20240136.5/2403A/R2/WY

24/03/2026

2-4 Burleigh St & 20-24 Railway Parade, Burwood - Acoustic Response to Submission

This letter has been prepared to respond to Department of Planning, Housing and Infrastructure (DPHI) request for information relating to the development application at 2-4 Burleigh St & 20-24 Railway Parade, Burwood.

LEVELS 3-18 ACOUSTIC NATURAL VENTILATION PLENUMS

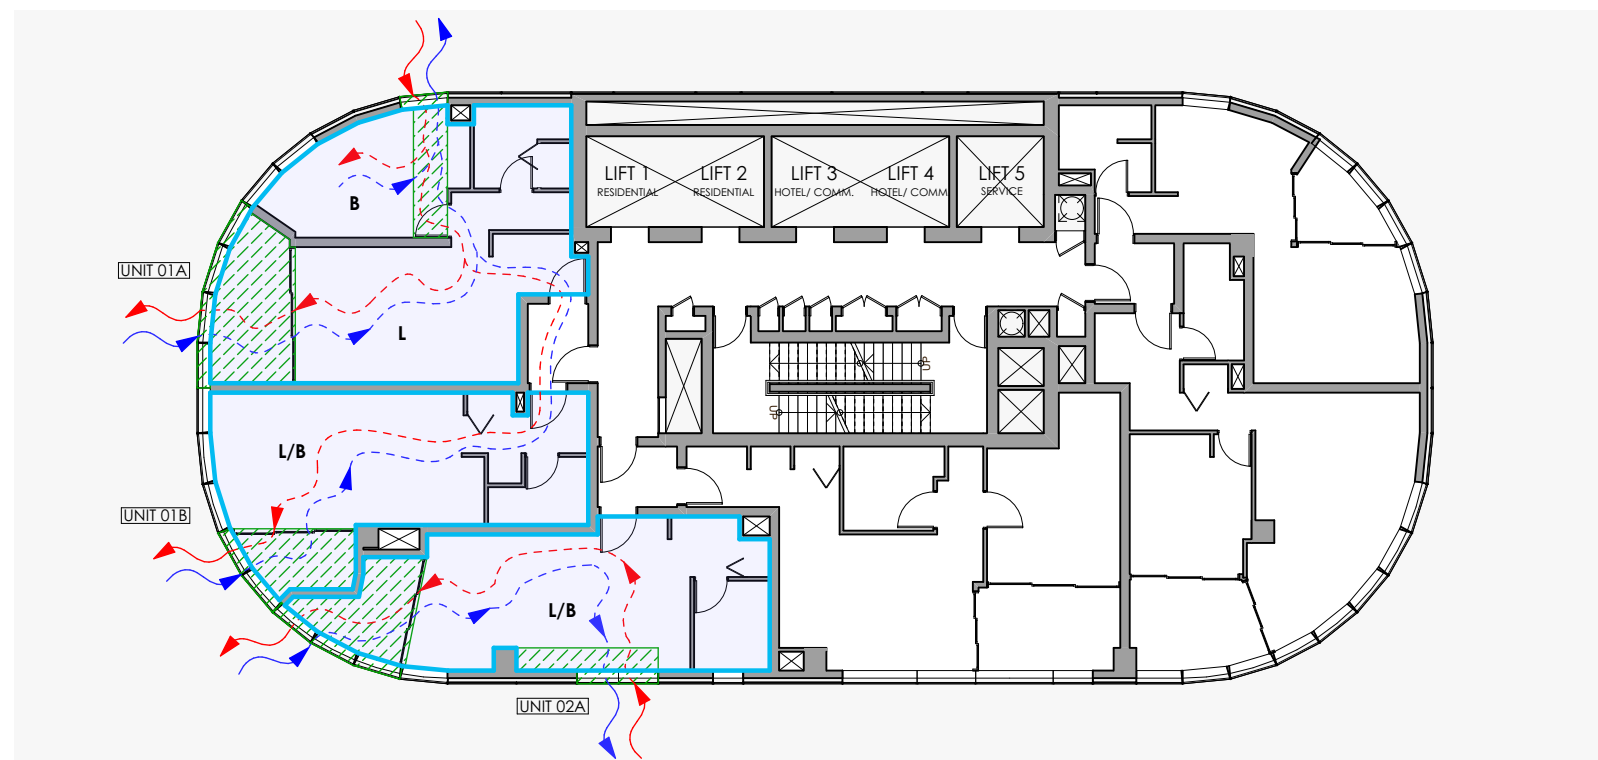
Item	DPHI RFI	AL Response
5	The revised NVIA advises that unit 1A, 1B and 2A will require windows be closed to achieve internal noise requirements. Provide an alternative ventilation assessment which demonstrates that adequate air flow can be achieved to the apartments for cross ventilation and updated architectural plans reflecting this system on the façade	The proposed alternative ventilation strategy is to provide a plenum to all noise affected apartments (1A, 1B and 2A). All other apartments can rely on open windows or doors for natural ventilation and still achieve internal noise level requirements. The following clarifications and are made: • Predicted façade noise levels at residential units up the tower are between 0-5dB(A) over the noise level that allows for untreated natural ventilation whilst complying with the internal noise requirements of the NSW Department of Planning Development Near Rail Corridors and Busy Roads – Interim Guideline 2009. • From the predicted façade noise level, the natural ventilation plenum is required to provide minimal noise reduction. • A sample calculation using a 900mm x 30mm open area plenum with 25mm thick internal insulation over the interior surface requires a minimum 300mm long acoustically treated natural ventilation plenum to achieve the required internal noise levels. • Final plenum sizing and treatment details are to be reviewed at CC Stage when the design has progressed Section 9.2 of the Noise and Vibration Impact Assessment has been updated to include this information.
